**Ballina High School Redevelopment (SSD 7742)
Notice of Exhibition**

Thank you for your letter dated 12 December 2016 requesting Transport for NSW provide comments on the above referenced Development Application.

**1 A-002 SITE PLAN**  
1 : 400

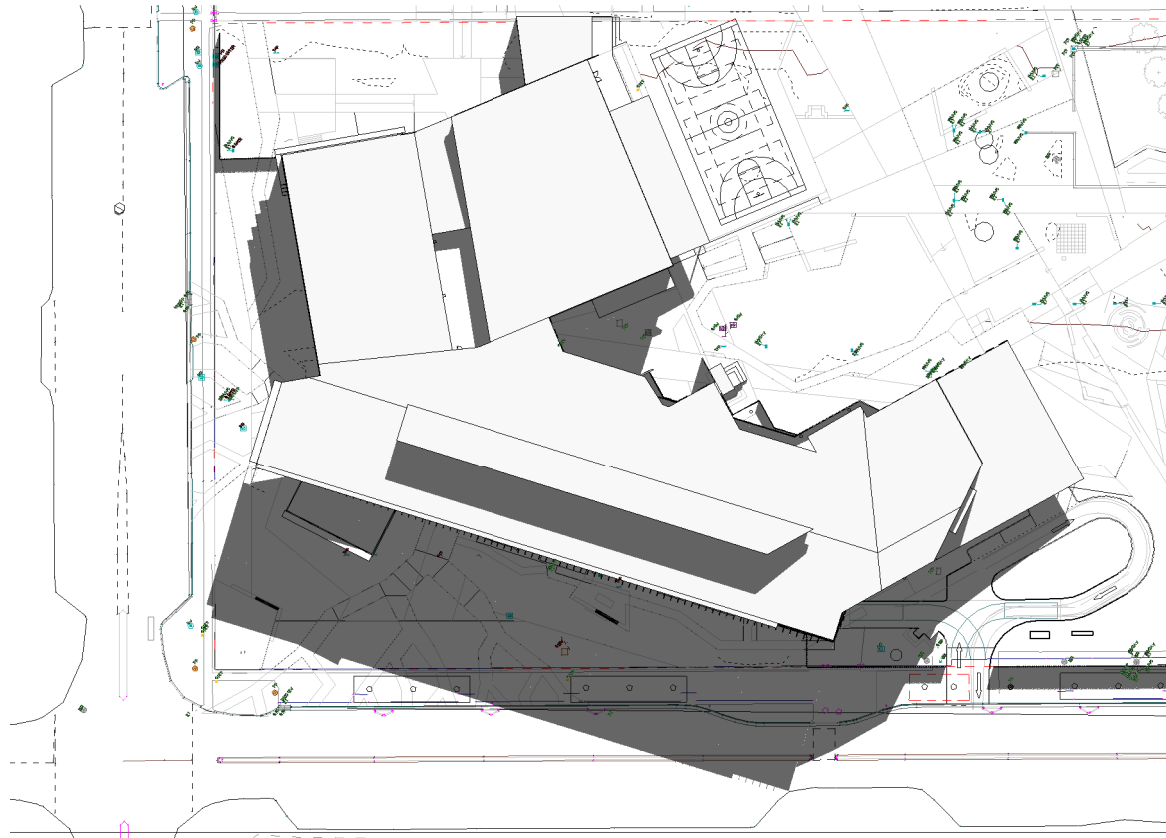
The Traffic Impact Assessment (TIA) in section 5.5 (page 27) 'School Buses' states that under existing conditions an 8 bay bus zone is located in Swift Street, with additional 2 spare bays in Martin Street. It should be noted that under existing conditions, the High School has 476 students. However, with the redevelopment proposal it envisages accommodation of over 1,000 students. Within section 5.5, the TIA states that it is the proposal's intention to reconfigure the existing bus bay space in Swift Street to only four bay bus zone, which is not supported by TfNSW on the following grounds:

- The proposal intends to increase student numbers from 476 to over 1,000, which will likely result in an increase of school buses to service to needs of the proposal;
- The Swift Street bus zone operates as a transfer point for students for other schools (such as St. Francis Xavier School), which has been acknowledged in the TIA (page 30), and;
- The proposal has not given any indication as to why any 'reconfiguration' needs to occur.

The safe alighting and boarding of school students from bus services is paramount. TfNSW recommends the Department of Planning and Environment condition the approval of SSD 7742 to require the existing 8 bay bus zone be retained as part of the redevelopment of the Ballina High School on safety and operational grounds.
